Subject : Heat Conversion - Shalom Apts., 180 Auburn St.

Re: Heat Conversion, The Shalom Apartments, 180 Auburn Street, Portland, Maine

Following are responses to your comments dated September 17, 2003.

Drawing:
MECHANICAL
ROOM 100 - PLANS

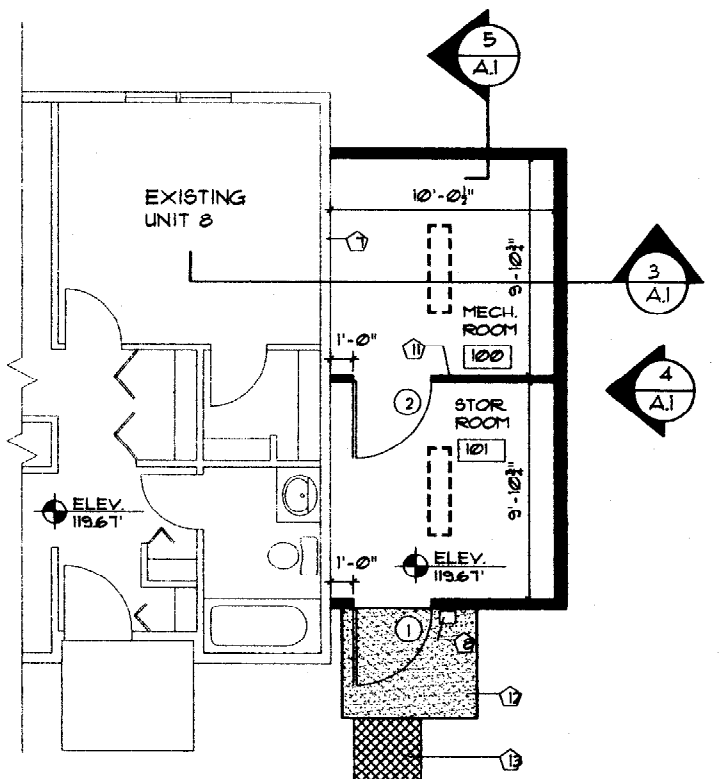
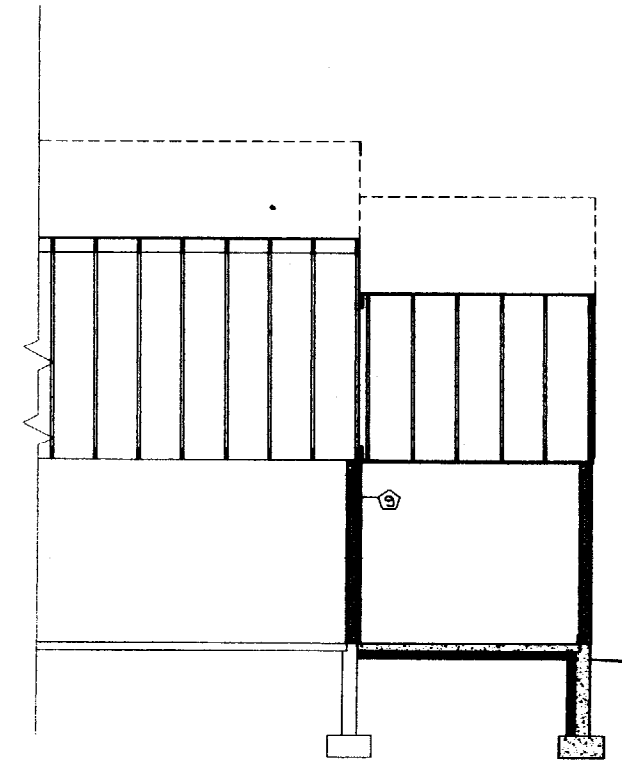
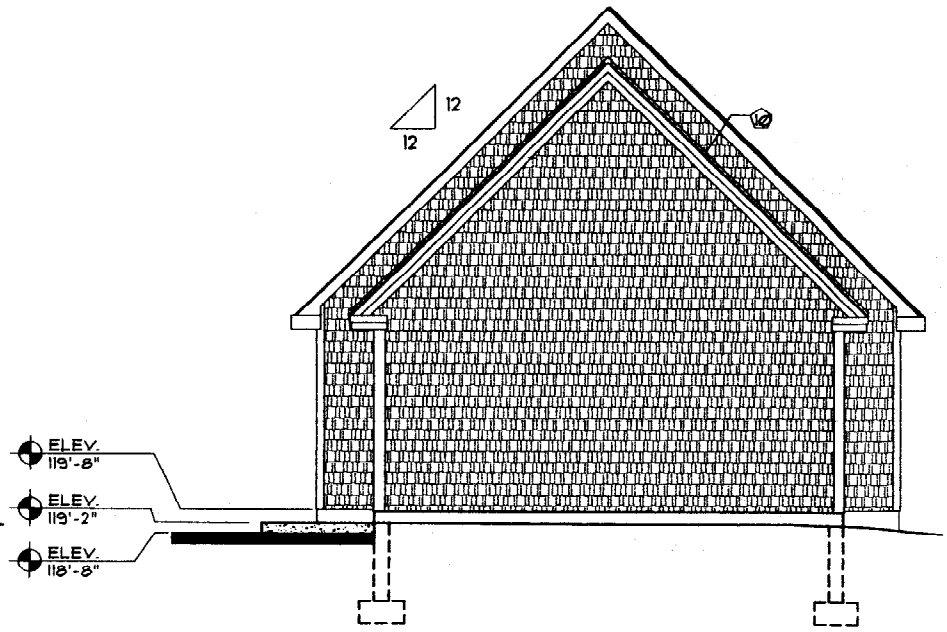
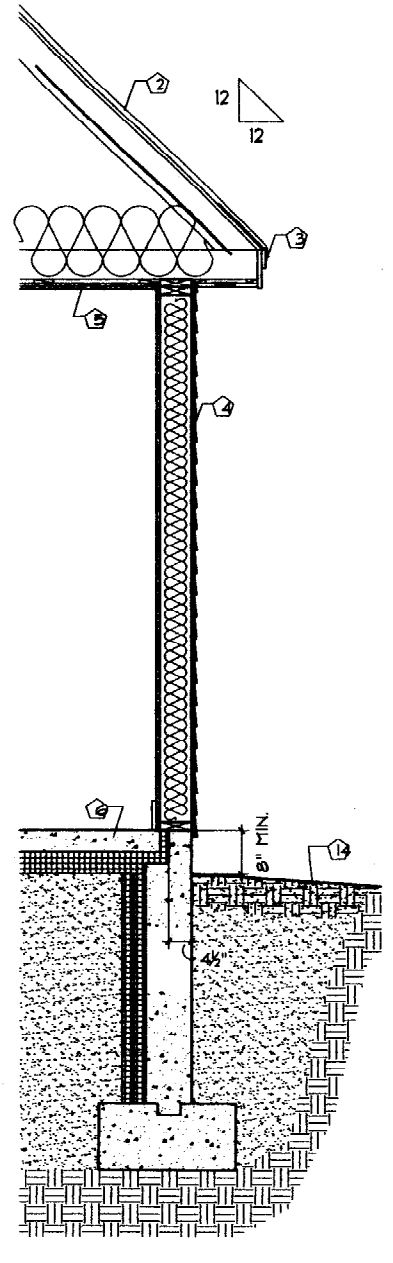
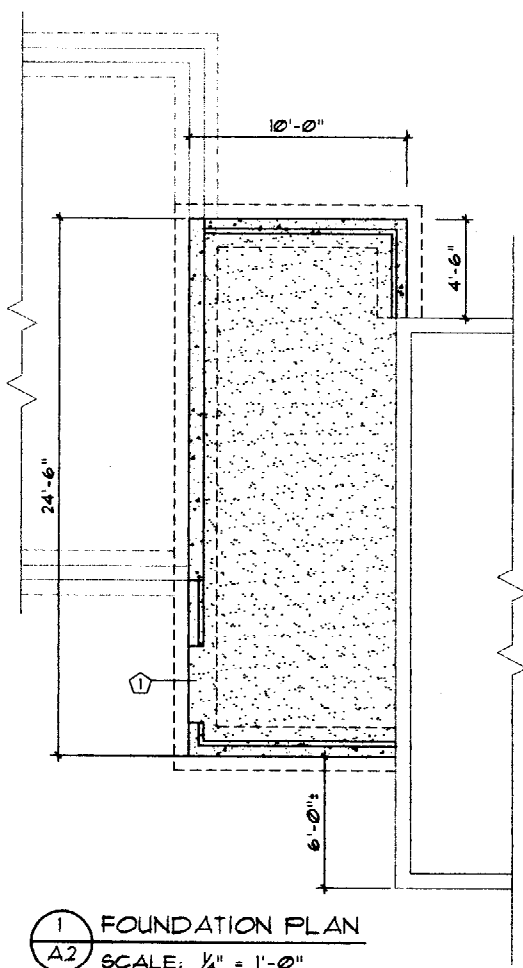
1. To insure that Storage Room separation walls are (1) hour rated Note #9 on Drawing A.1 will be amended to read: "Typical Mech. Rm. & Storage Room Separation Wall, (2) layers 5/8" FireCode G.B. – ptd.
